To: Development Review, El Paso County
From: Jonathan Bradley, Fire Marshal
Subject: Urban Landing PUDSP
Date: July 31, 2024

CCES Responses

The Monument Fire District has reviewed the PUD development plan for Urban Landing. Based on our initial review of site access, water supply, and fire mitigation, we have the following comments.

URBAN LANDING
PUD DEV. PLAN & PRELIMINARY PLAN
SITE PLAN SHEET

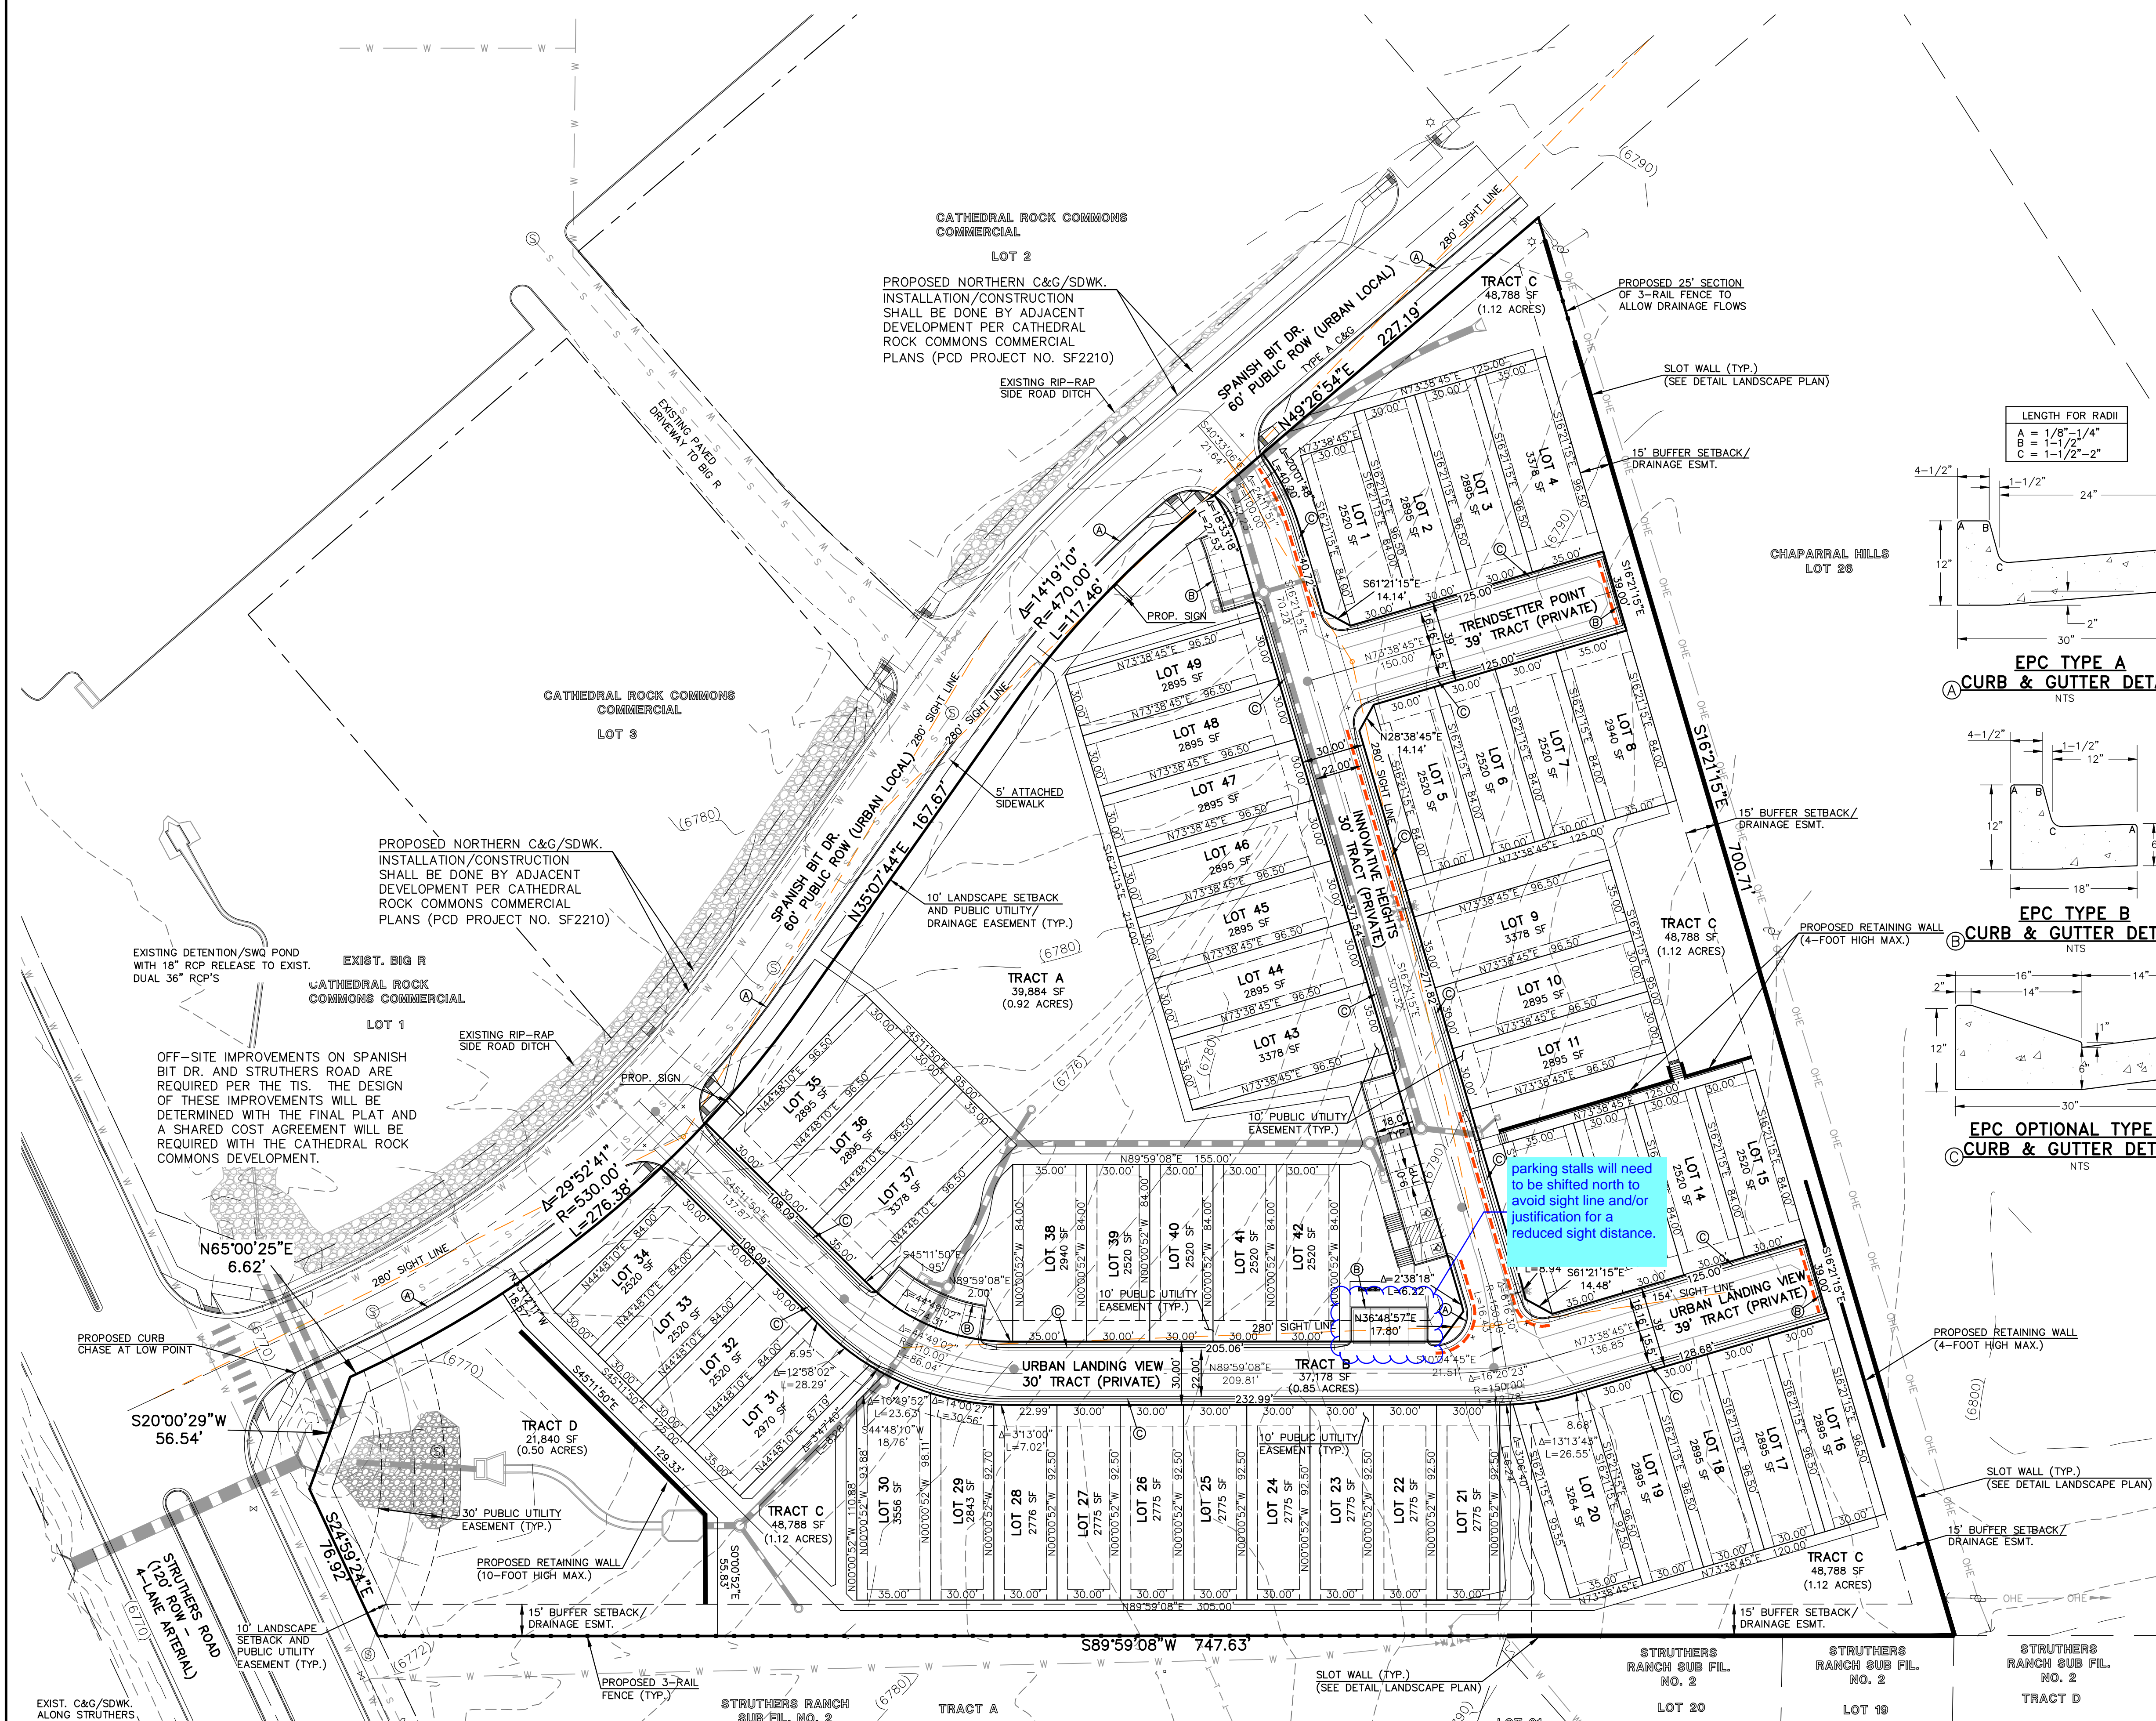
- FD prefers EPC Optional Type C curb and Gutter throughout the development (except designated parking areas) due to narrow roadways to allow large fire apparatus to mount the curb while turning or passing without damaging wheels and tires (see page 3 of 9 in PUD Development Plan). **Revised all areas to be Type C (ramp) curb except for parking, inlet locations and curb returns**
- Evaluate turning radius for attached fire apparatus drawing and determine if proposed roadways will accommodate large vehicle operation. **See attached fire access exhibits**
